26 November 2021

2190140

**RE: Response to Request for Information, Bays 1-4a of the Locomotive Workshop, South Eveleigh (SSD 8517, MOD 7)**

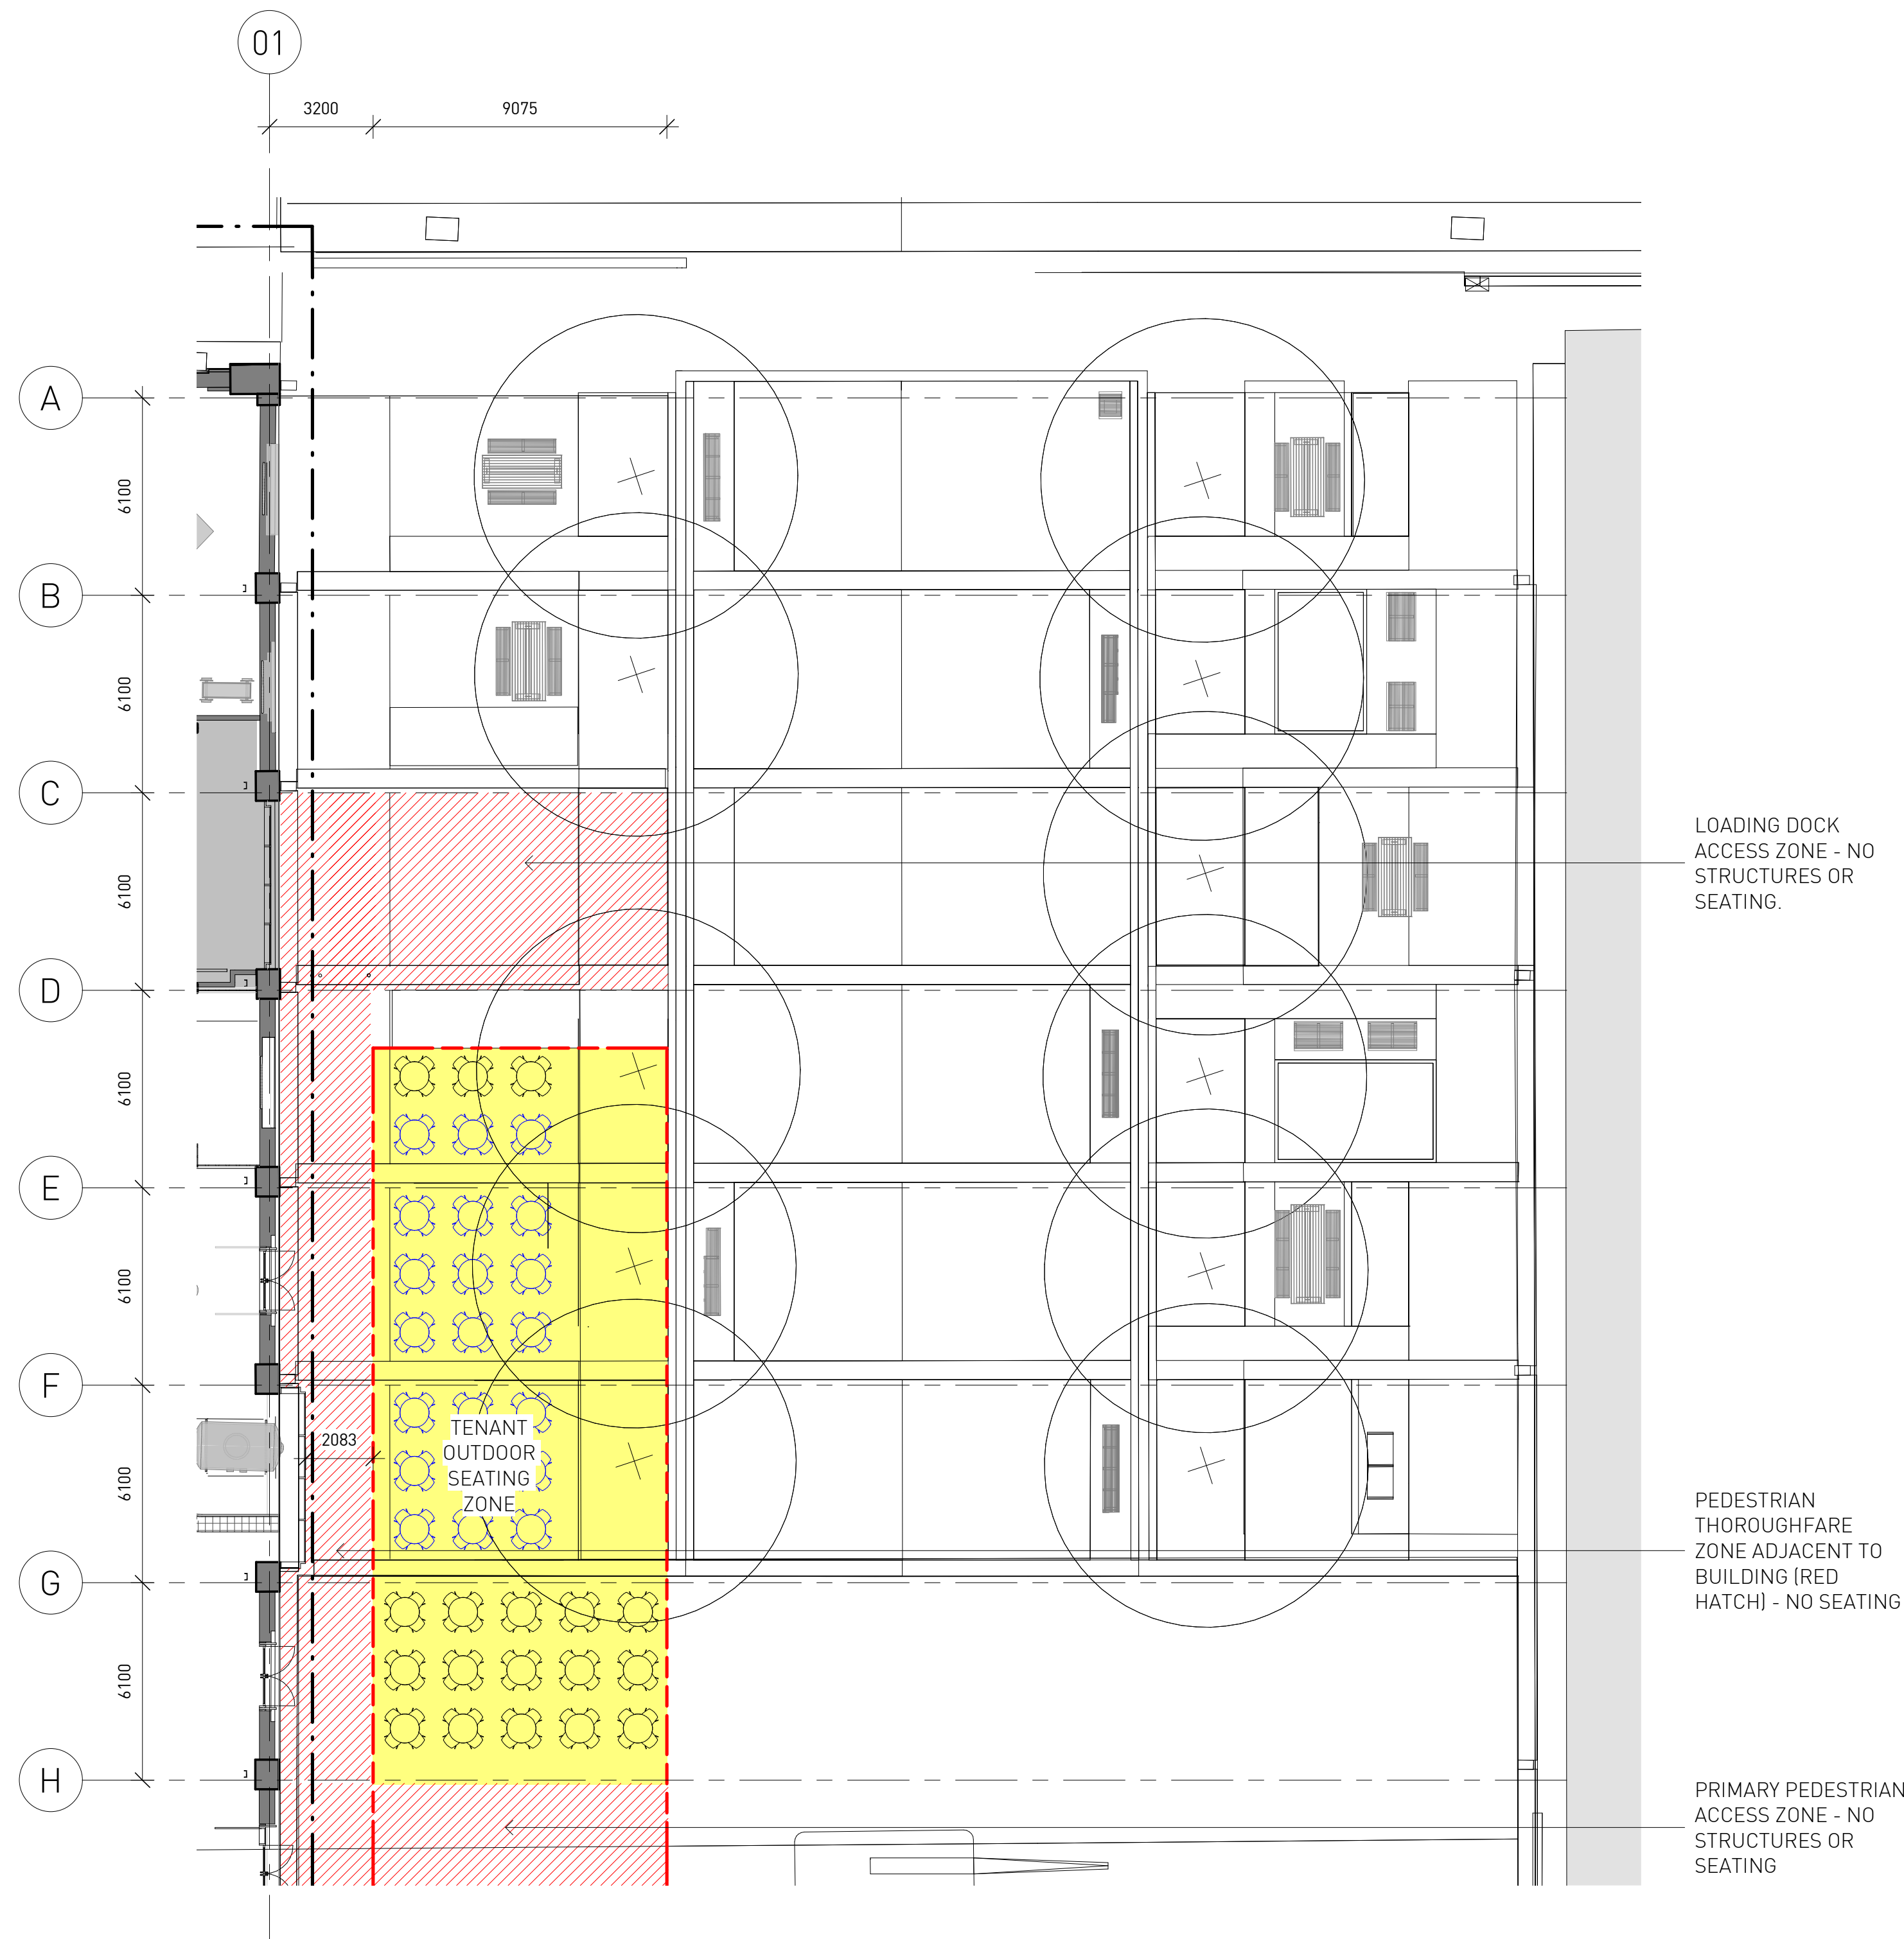
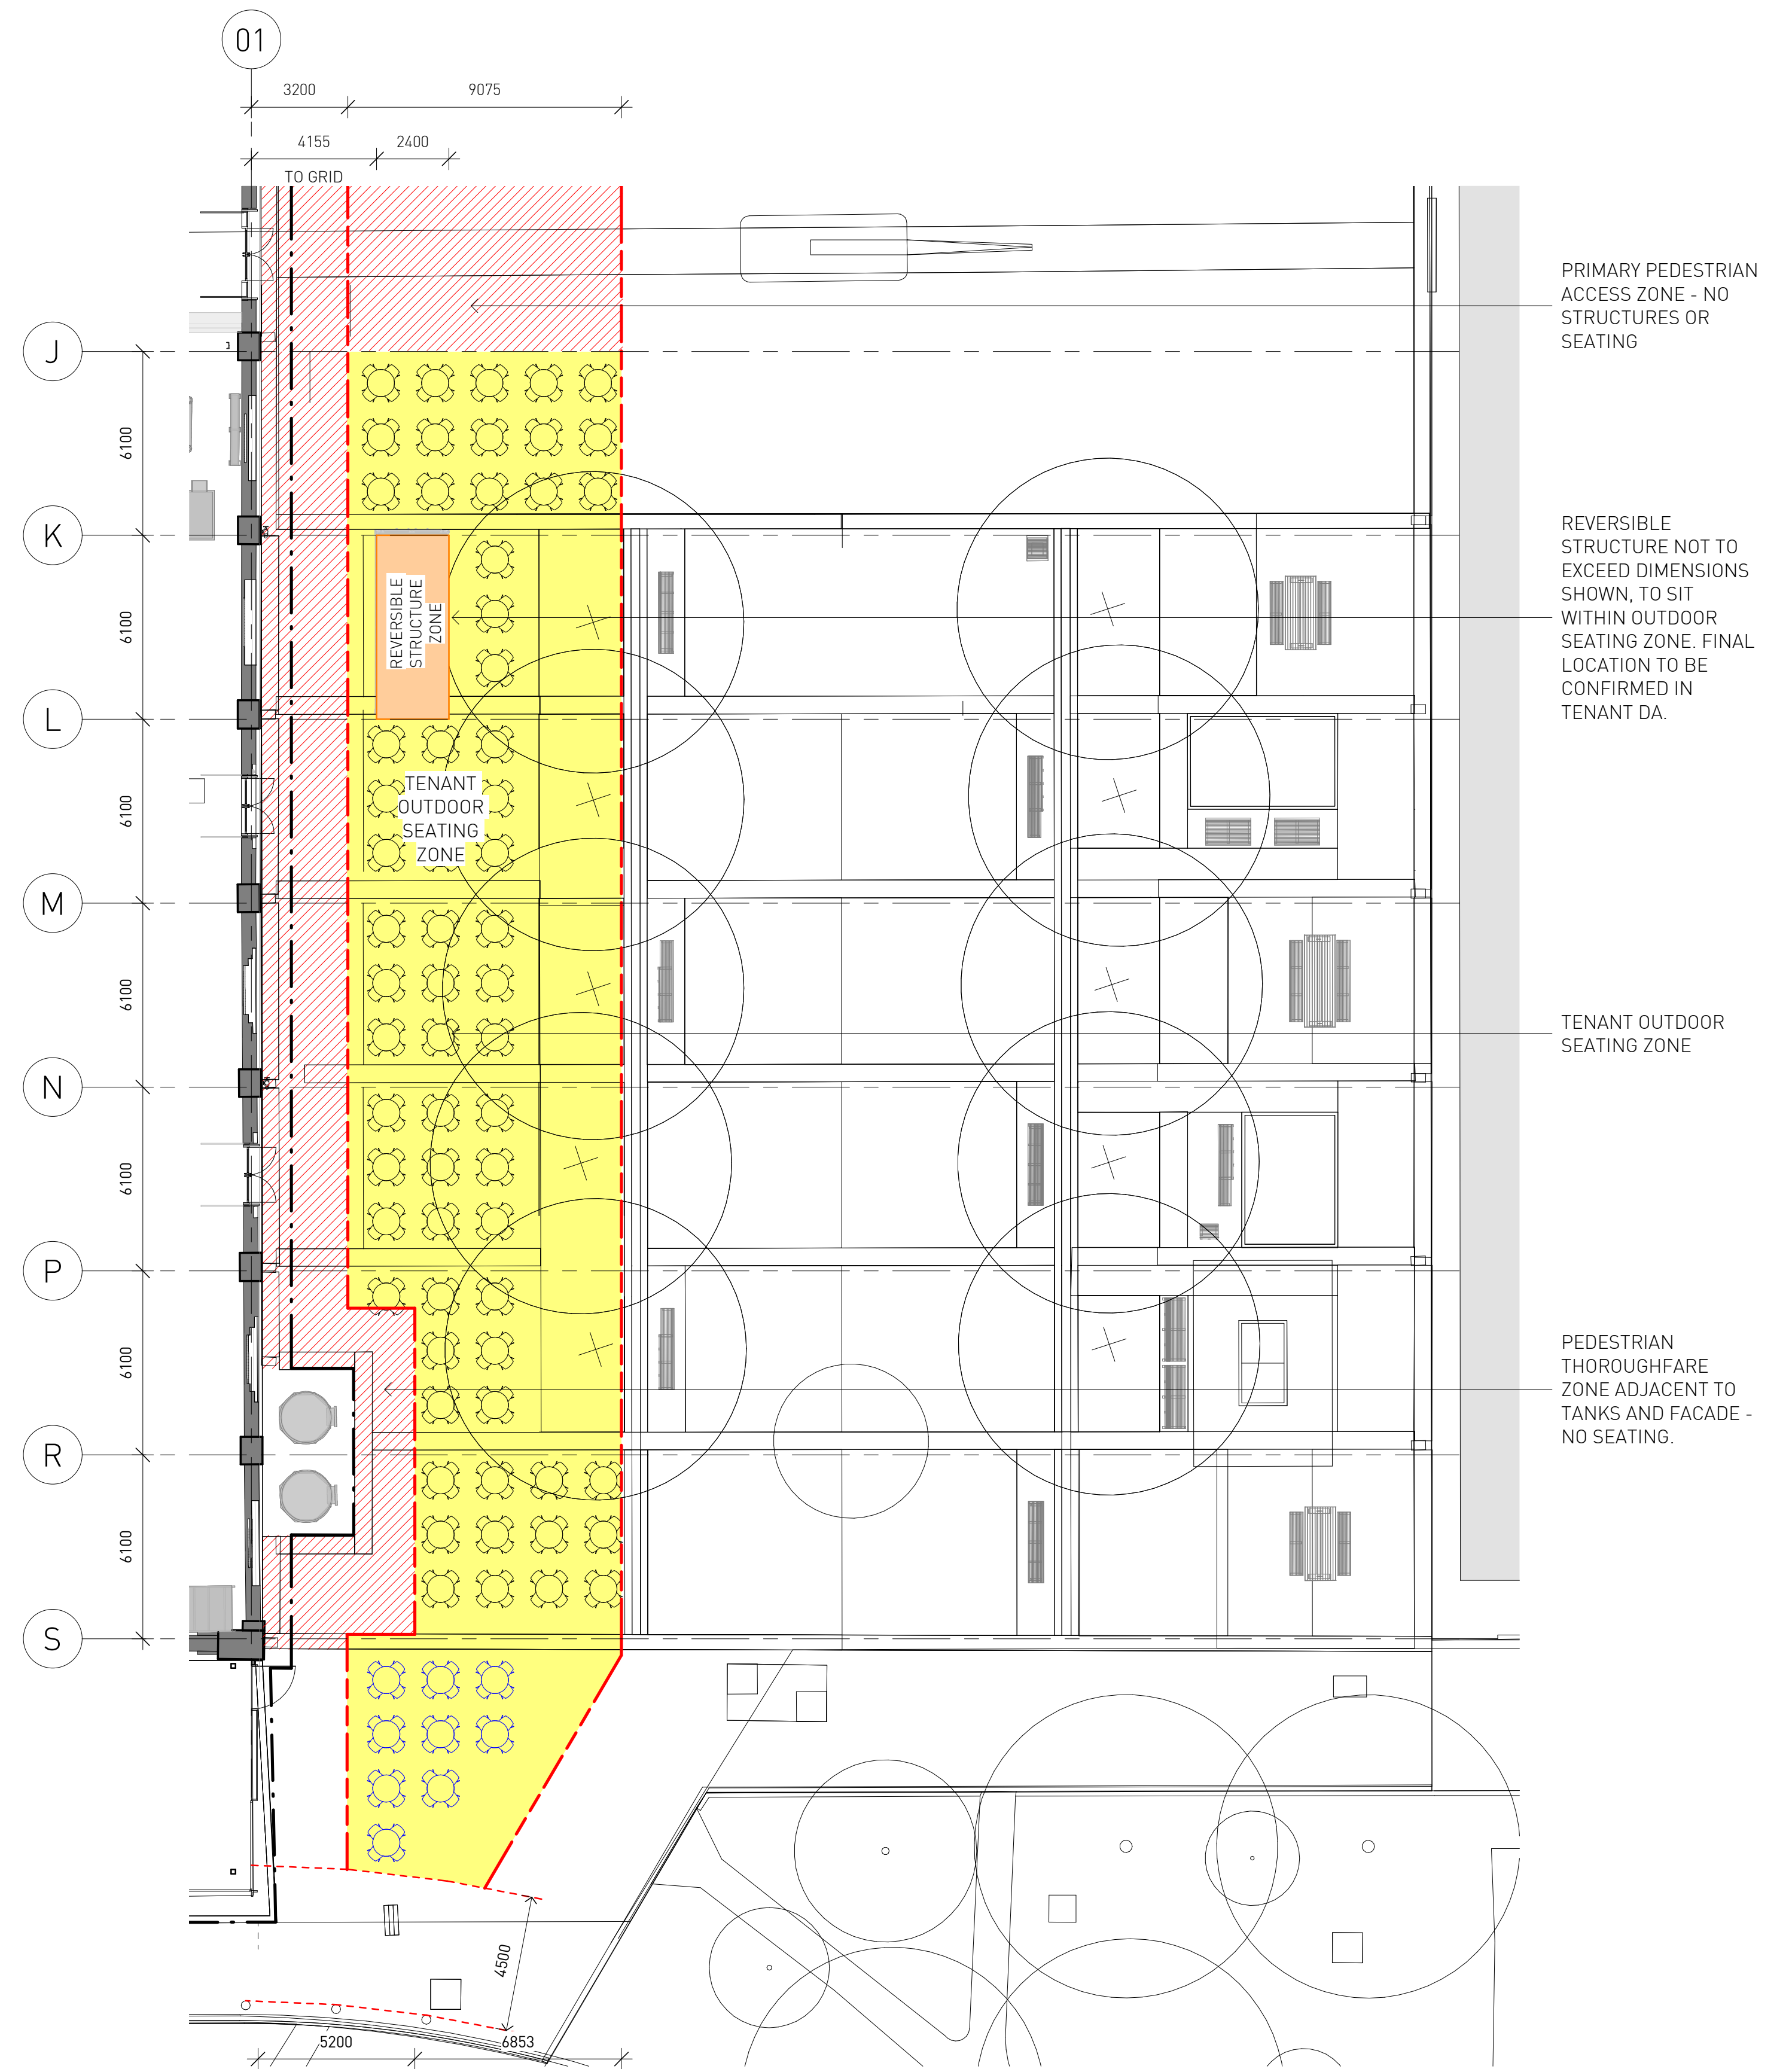
*Confirm if the southern seating area added to drawing SK-0936 fronting Locomotive Street would still result in the expanded retail use occupying 16% of the total area of Innovation Plaza.*

- Site Retail Plan, SA-AR-DWG-BB-B\$-0304, Rev U
- Proposed Plan – Ground Floor, SA-AR-DWG-BB-B4-0330, Rev DD
- Proposed Permanent Land Use Plan, SA-AR-DWG-BB-B4-0390, Rev M
- Proposed Area Plan – Innovation Plaza – Ground Floor, SA-AR-DWG-BB-B4-0395, Rev C
- SK\_096, Rev E. For this plan, please delineate and overlay the approved outdoor seating areas with the proposed expanded retail areas.

The approved southern-most seating area, as added to the architectural drawings falls within the Business Zone – Business Park zone as illustrated in **Figures 1** and **2** below. As illustrated on Plan SA-AR-DWG-BB-B4-0395 as being approximately 151m<sup>2</sup> in area, given this area falls within the Business Zone – Business Park zone, it does not result in any change to the expanded retail use area occupying 16% of the total area of the Recreation Zone – Public Recreation zone that covers the majority of Innovation Plaza.

In addition, the Proposed Area Plan – Innovation Plaza – Ground Floor (SA\_AR-DQG-BB-B4-0395) and SK\_096 do not have red clouding on them as these are new plans introduced to the set as part of this modification application. Notwithstanding this, the plans clearly differentiate between the approved outdoor seating areas and the proposed expanded seating areas through the use of different coloured seating illustrations.
